CONSULTEE RESPONSE (Arun District Council - Arboriculturist)

Reference: AL/35/26/RES

Proposal: Approval of reserved matters following outline consent AL/178/22/OUT for appearance, landscaping, layout and scale for the construction of 89no. residential dwellings, together with open space, landscaping and associated infrastructure, with access taken from Meadow Way (resubmission following AL/137/24/RES). This application is in CIL Zone 3 and is CIL Liable as new dwellings.

Location: Land rear of Meadow Way, Westergate

SCALE 1:1500 @ A3	DATE APR 2026	DRAWN GW
DRAWING NUMBER 12083 TPP_02 (Overview)	REVISION

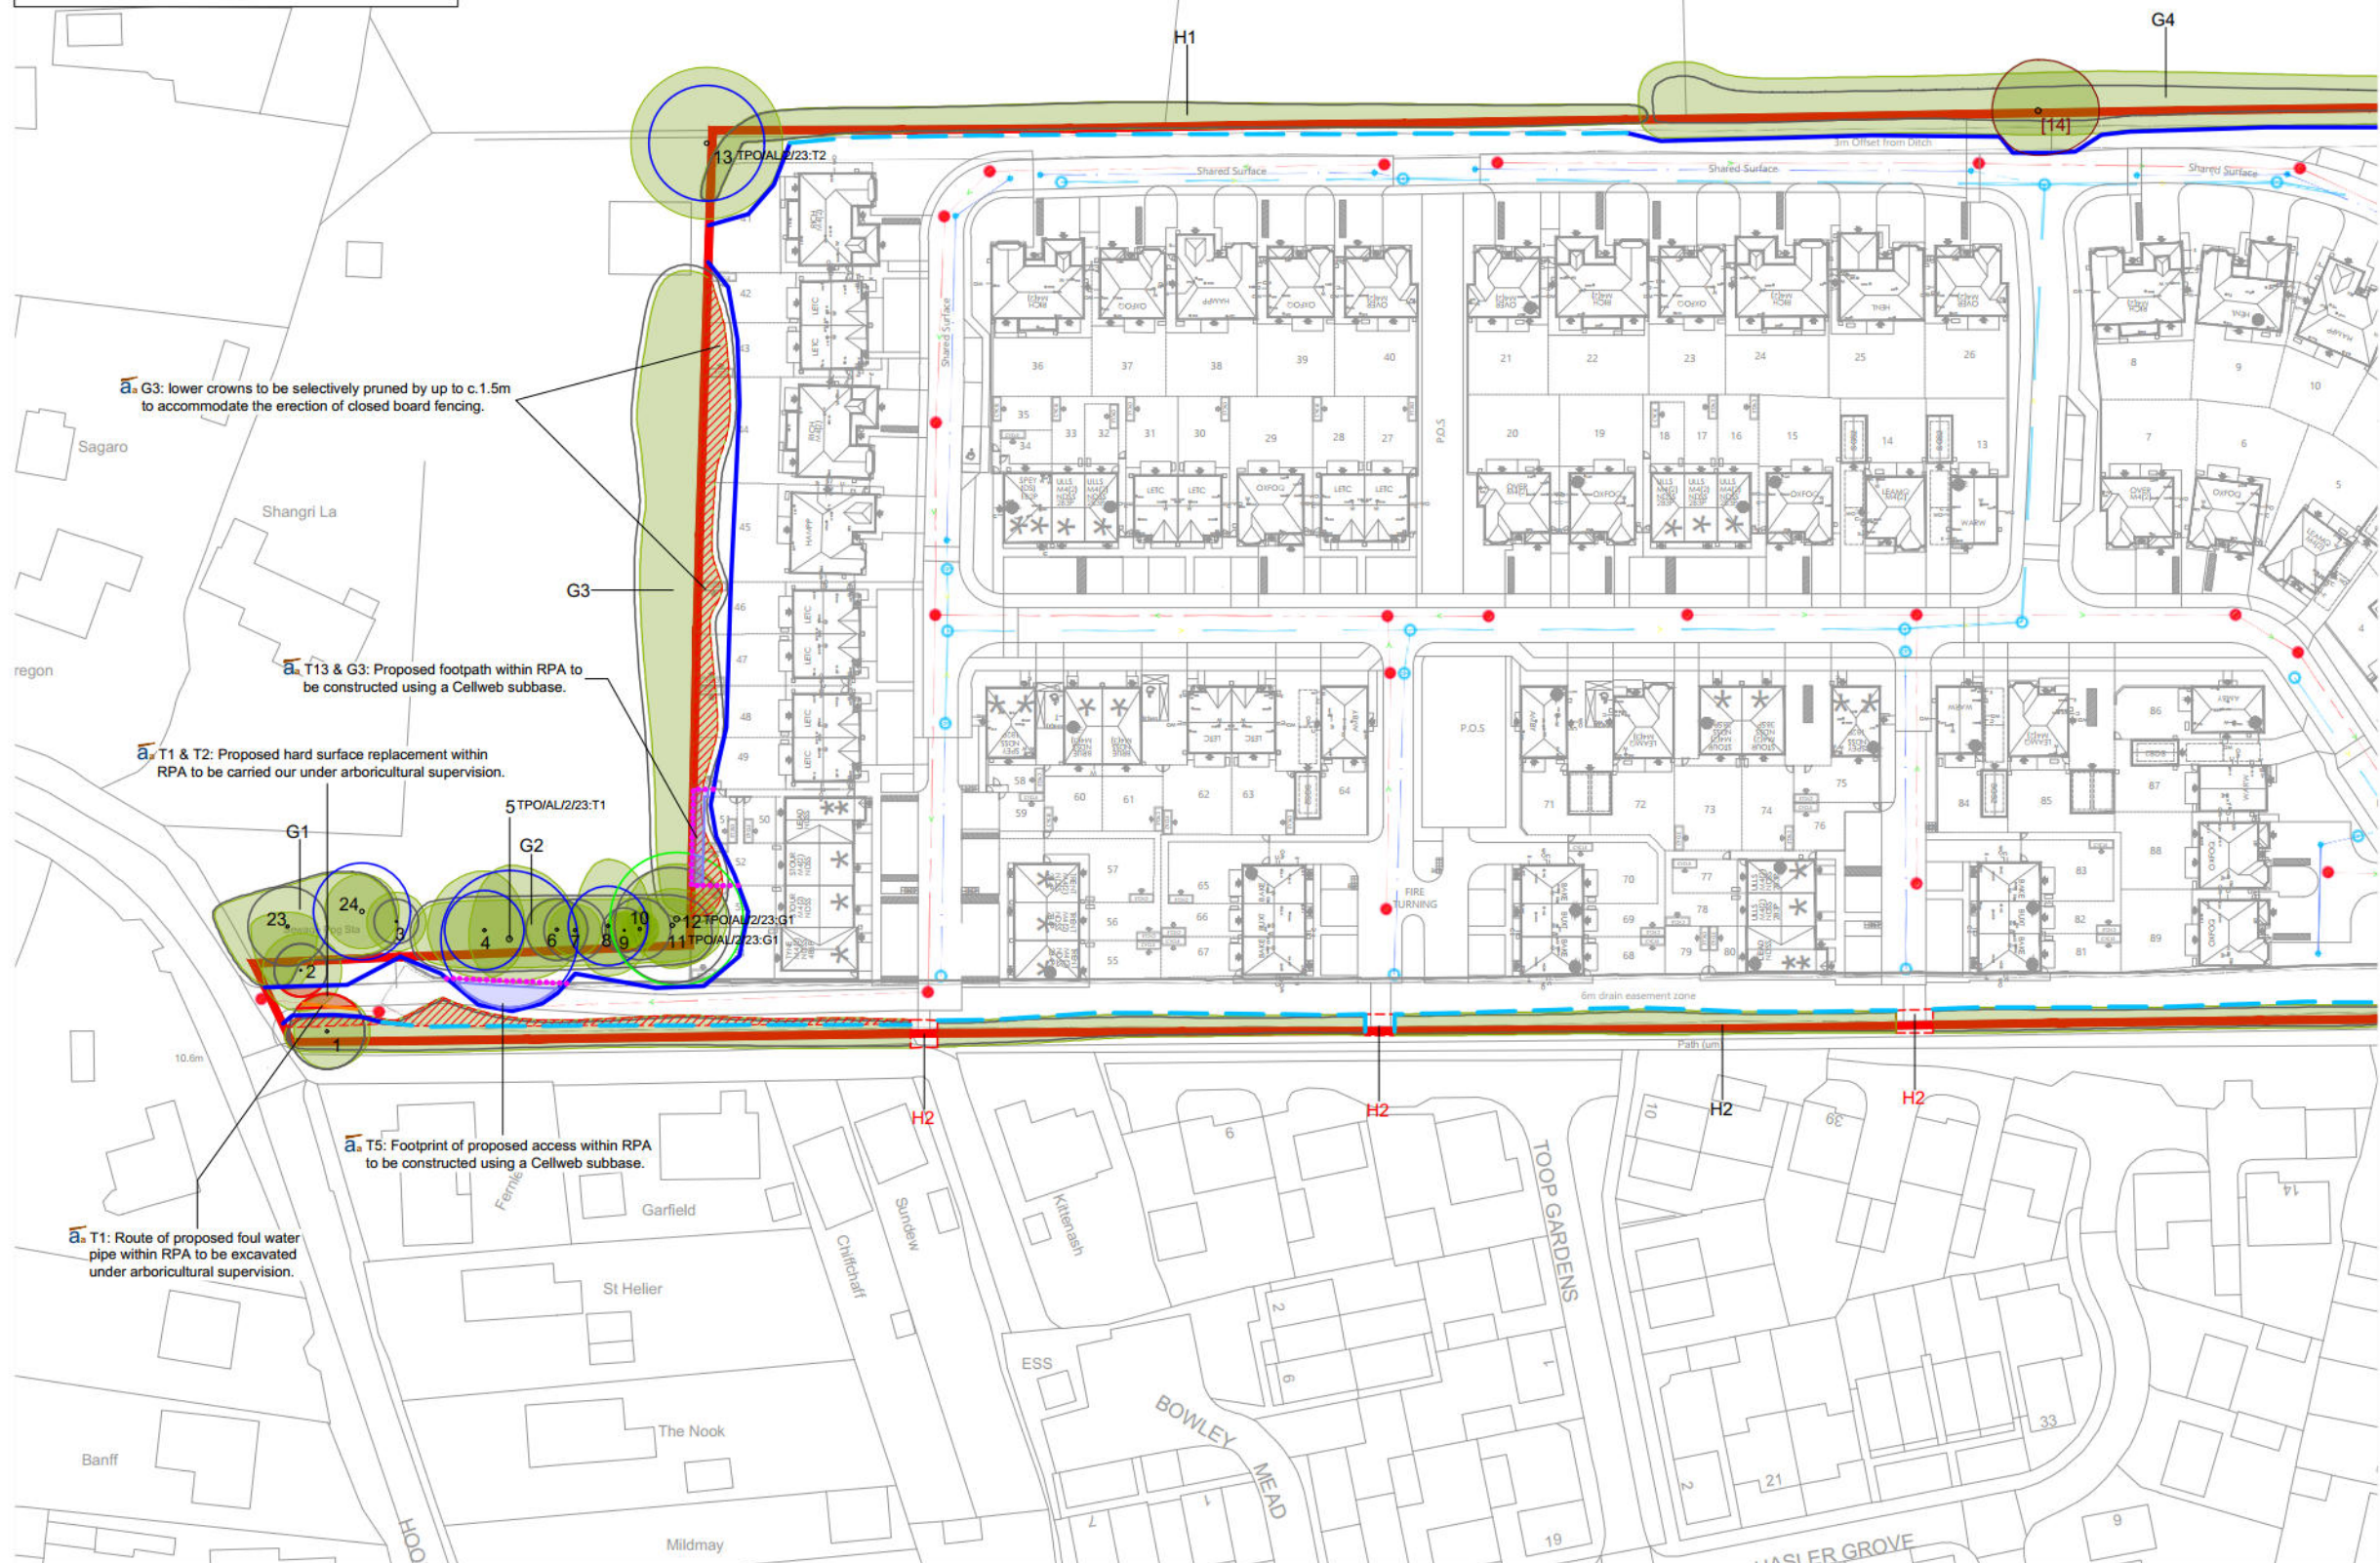
Before any machinery is introduced to the site or construction work takes place, a brief written report (with supporting photographic evidence) is required from the Arboricultural Consultant representing the site owner(s), confirming and demonstrating that all ground protection and protective fencing has been assessed and is 'Fit for Purpose' as required under British Standard 5837:2012 and been erected and positioned exactly as shown on the **Tree Protection Plan, dwg. nos. 12083 TPP_02**

SCALE 1:1000 @ A3	DATE APR 2026	DRAWN GW
DRAWING NUMBER 12083 TPP_02 (West)		REVISION

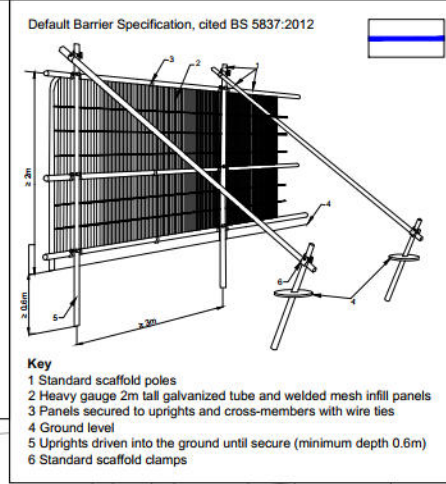
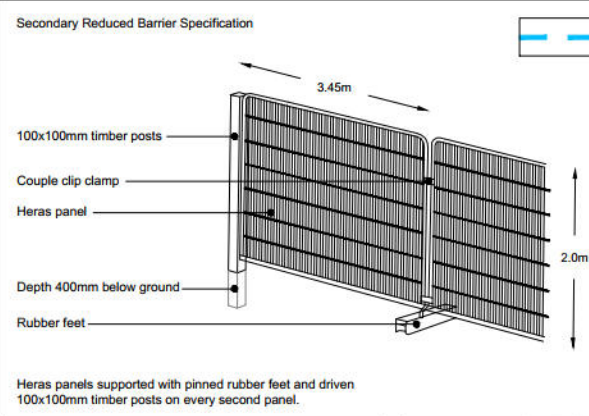
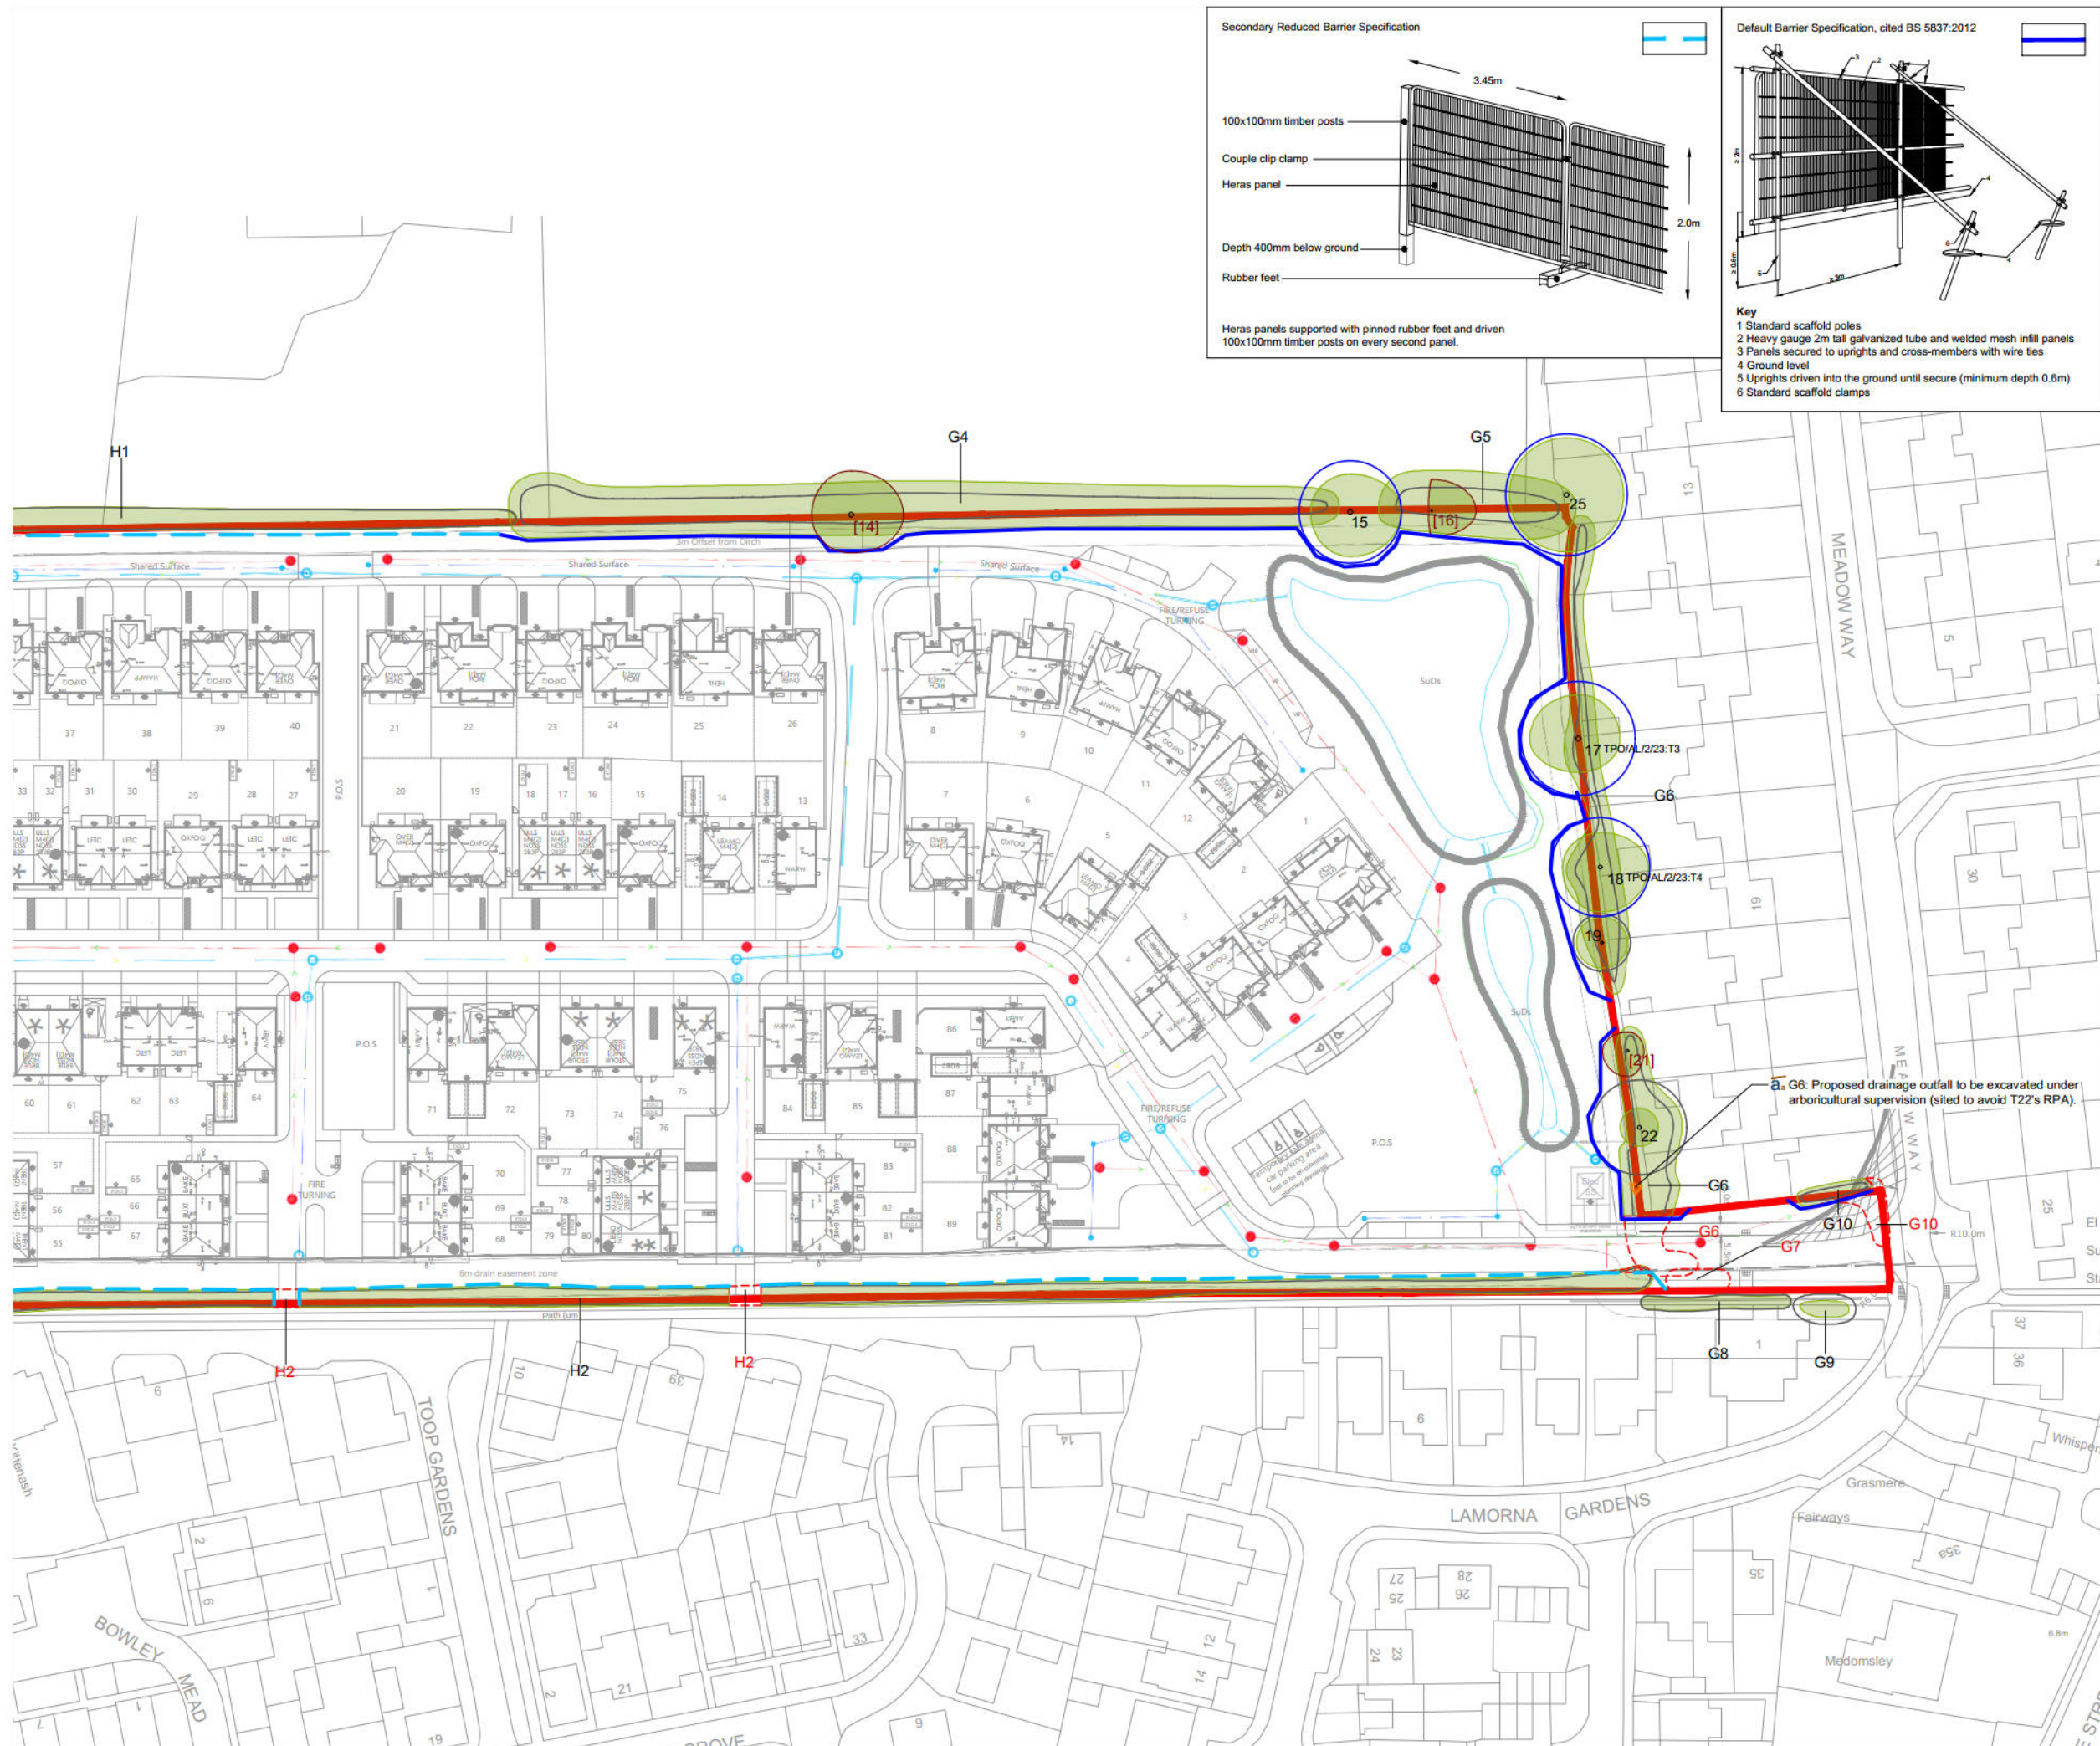
There is significant development incursion into the RPA of important trees, most notably at the site's western boundary. To mitigate risk of harm it would be necessary to control permitted development rights for the most affected plots. This should affect outbuildings and hard surfacing.

My previous objection to the layout proposal, so far as its impact on important trees overlapping plots 38 & 46-48 (effectively 41 & 52-54 incl. of this latest application) is overruled by the planning inspector's determination of appeal ref. APP/C3810/W/24/3356352

1. The use of an Article 4 direction to control permitted development rights within the root protection areas of T11, T12 and T13, affecting plots 41, 53 & 54. This should prevent the introduction of outbuildings or hard surfaces (i.e. Class E and F of the relevant Order) within the existing root protection area of trees subject of a TPO.
2. If the above scheme is recommended for APPROVAL, the following conditions should be applied:
